**JACKSON OFFICE WAREHOUSE & STORAGE BLDGS**

**8140 SANDY COURT  
EL PASO COUNTY, COLORADO**

## GRADING AND EROSION CONTROL PLAN

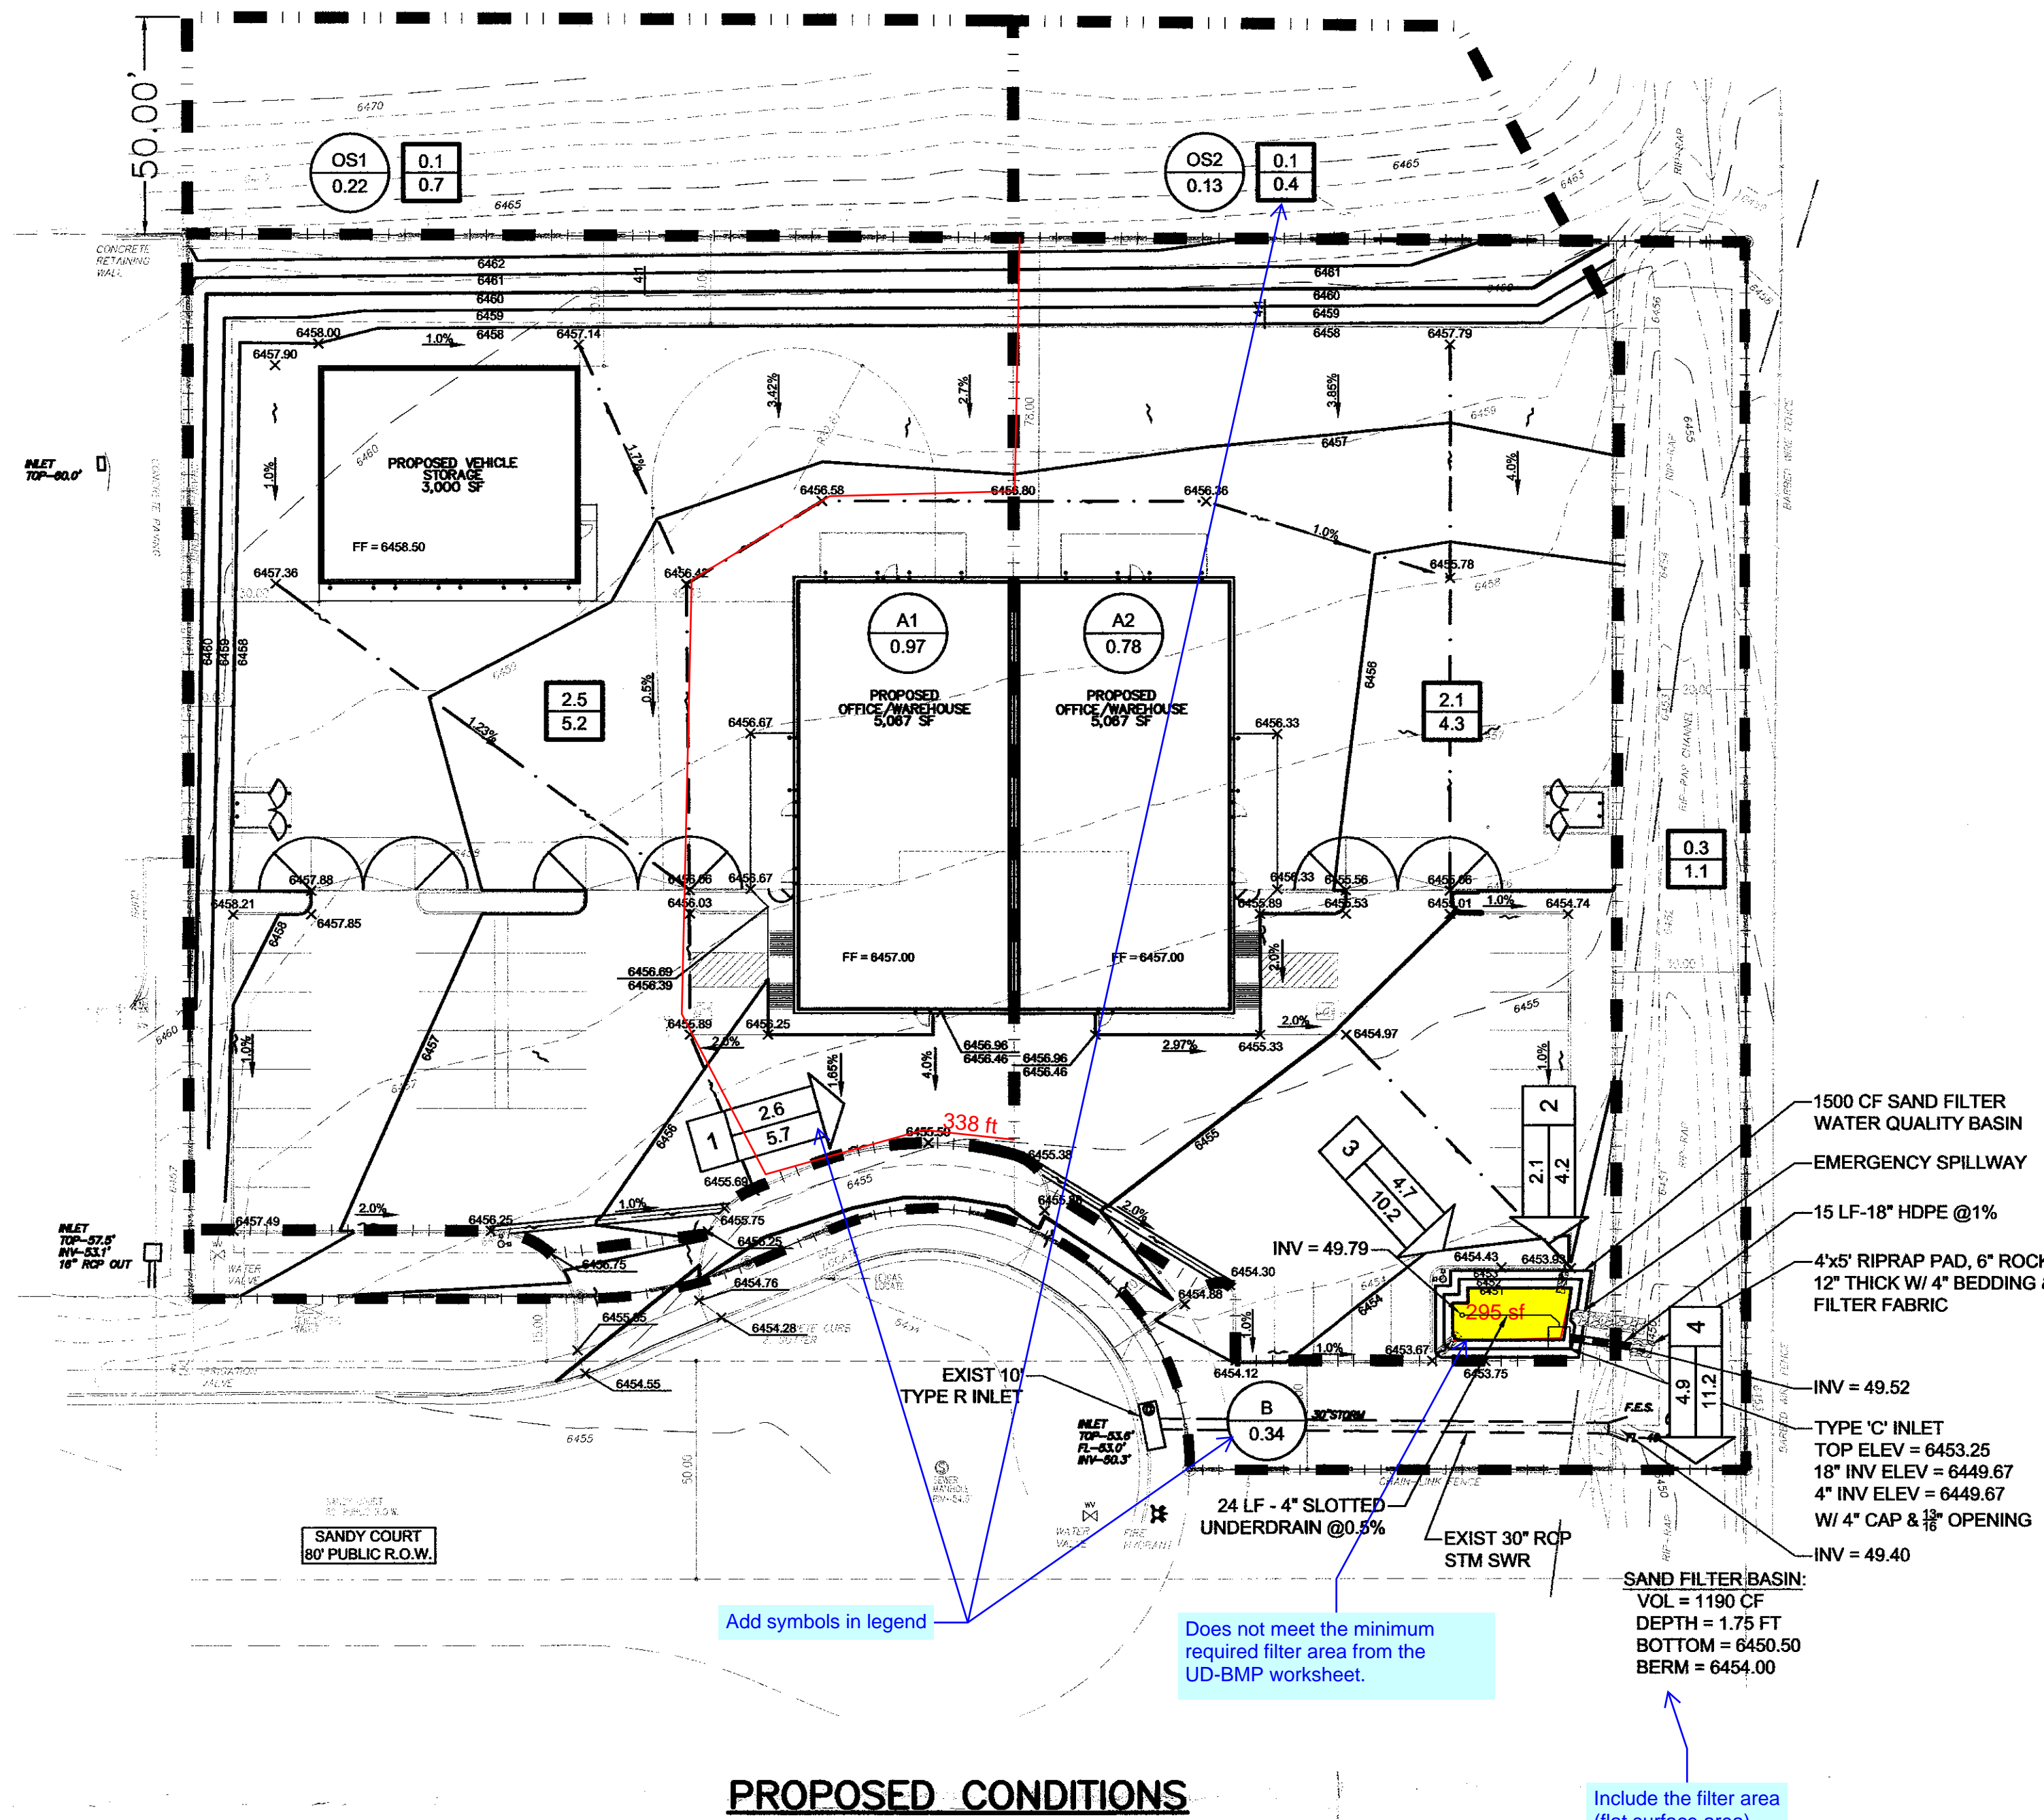
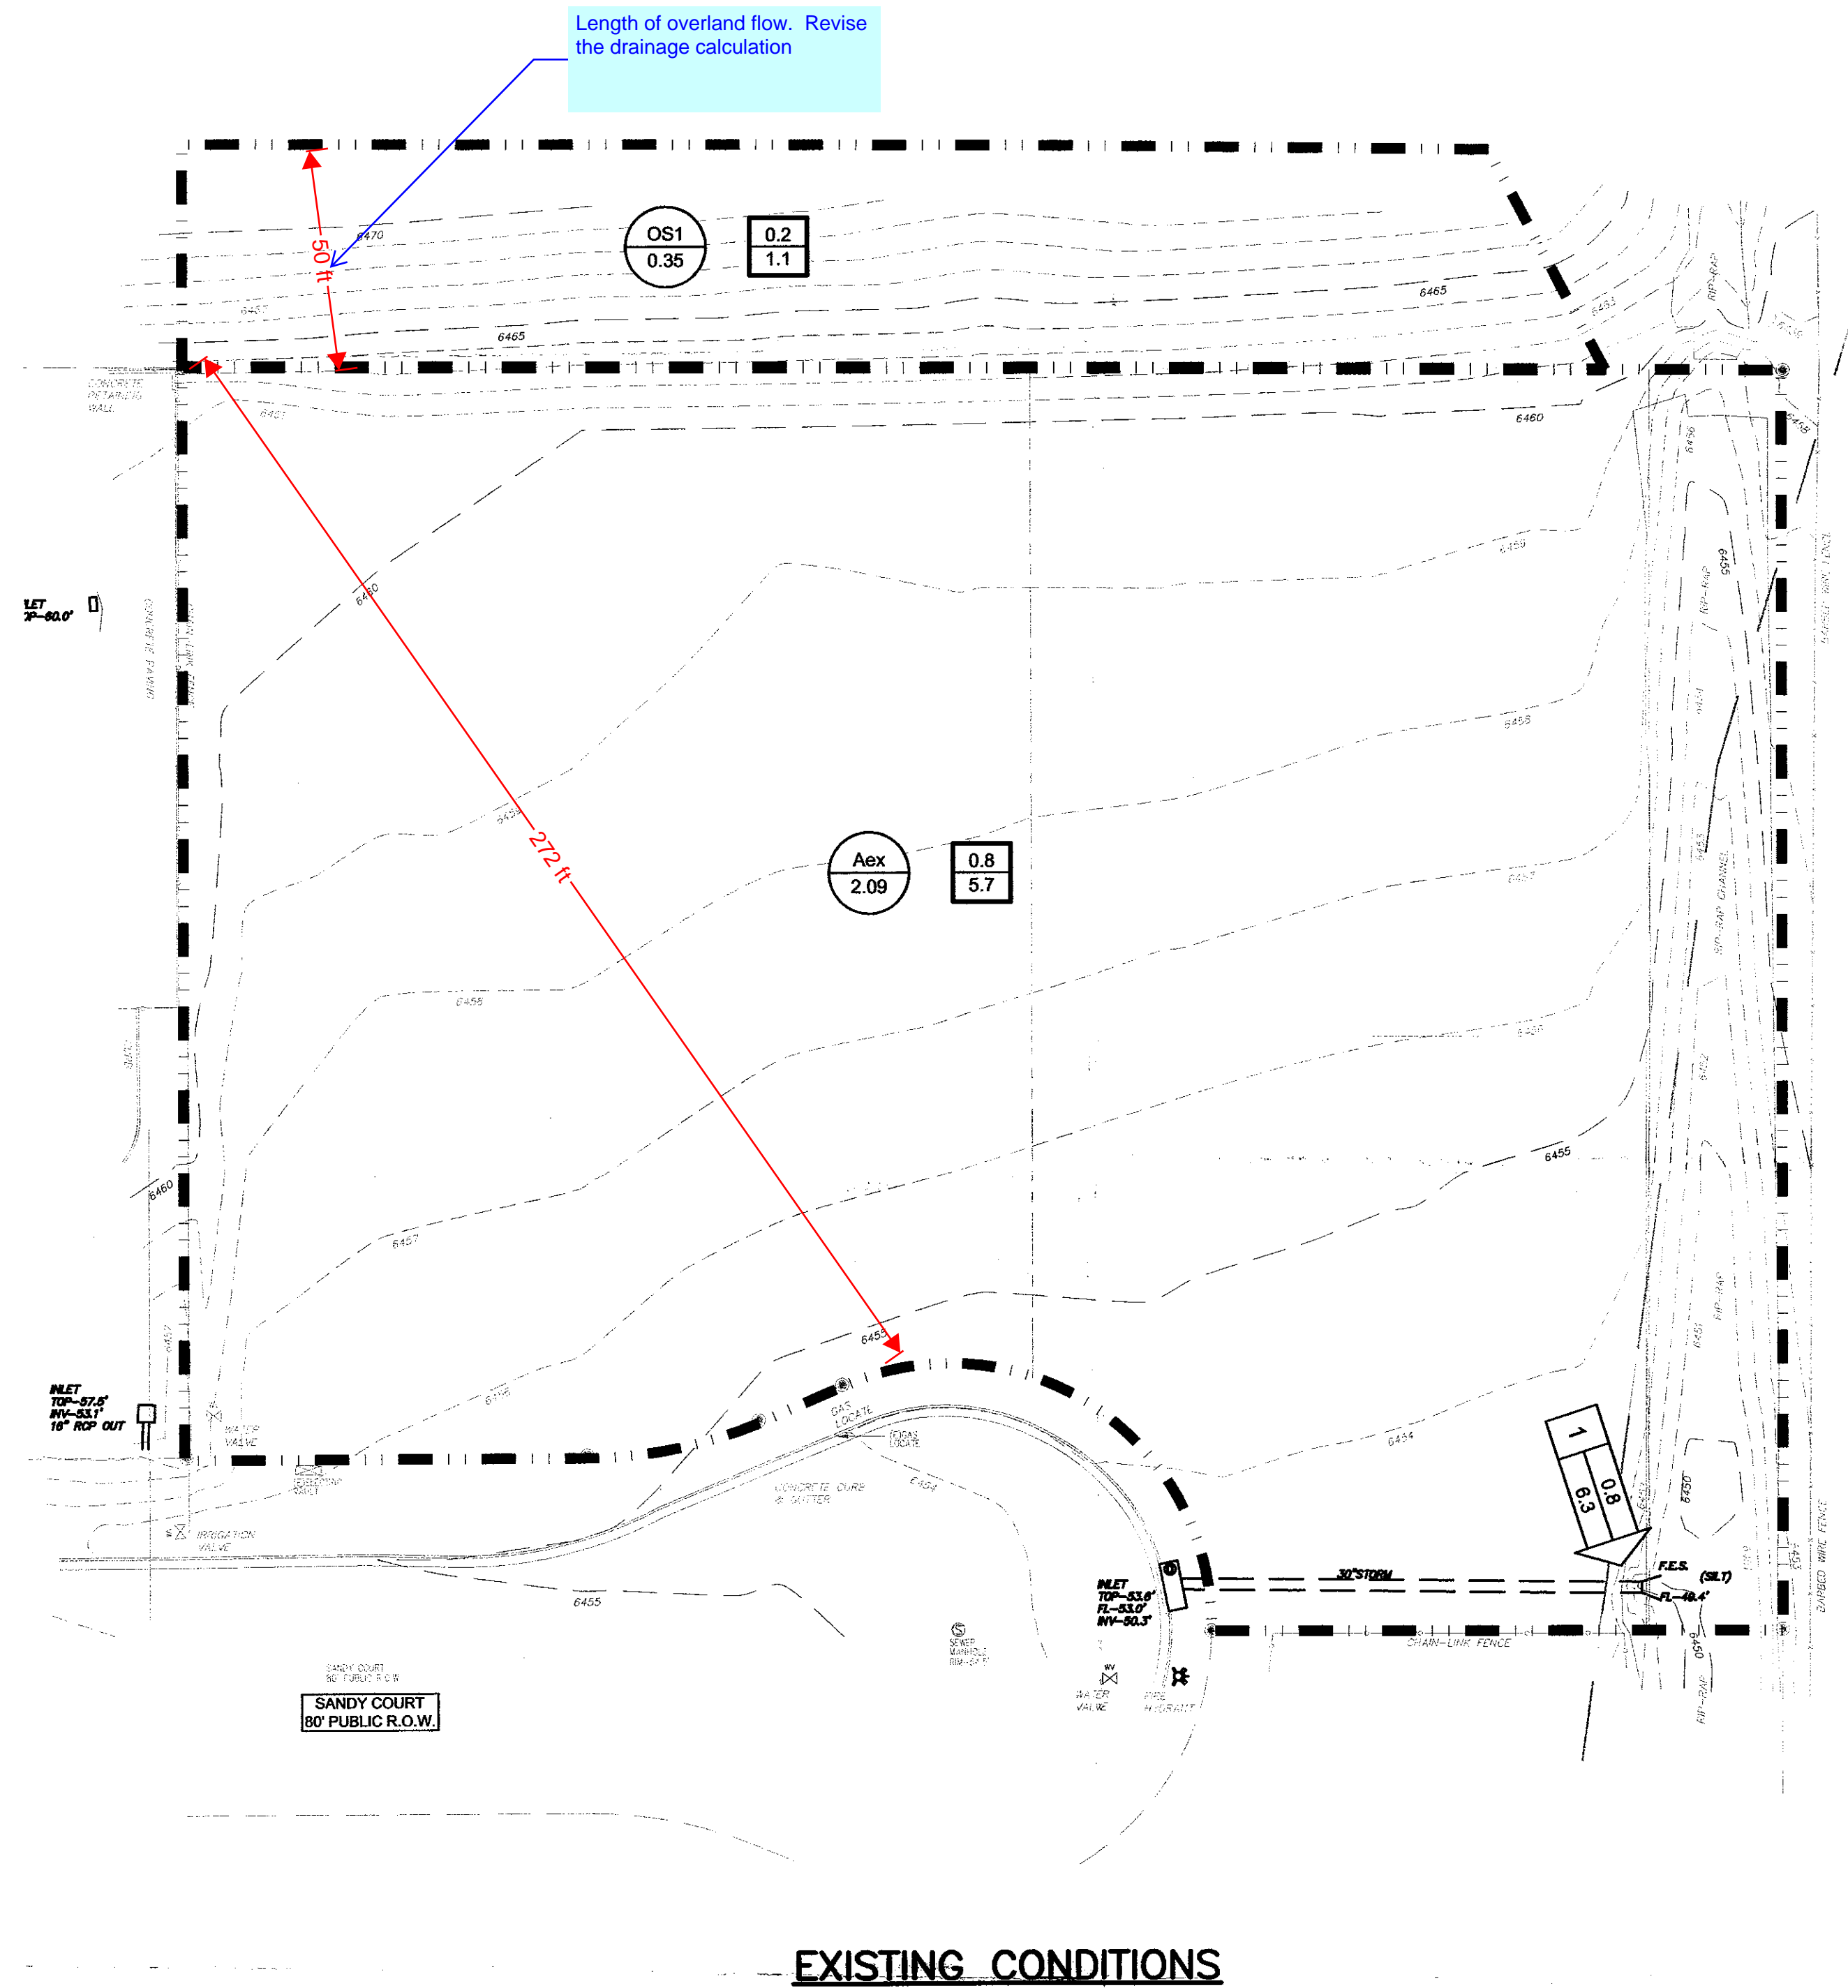
Unresolved. Coversheet and temporary & permanent BMP details must be a part of a Standalone Grading and Erosion Control Plan. See ECM Appendix E for the Grading and Erosion Control Plan checklist.
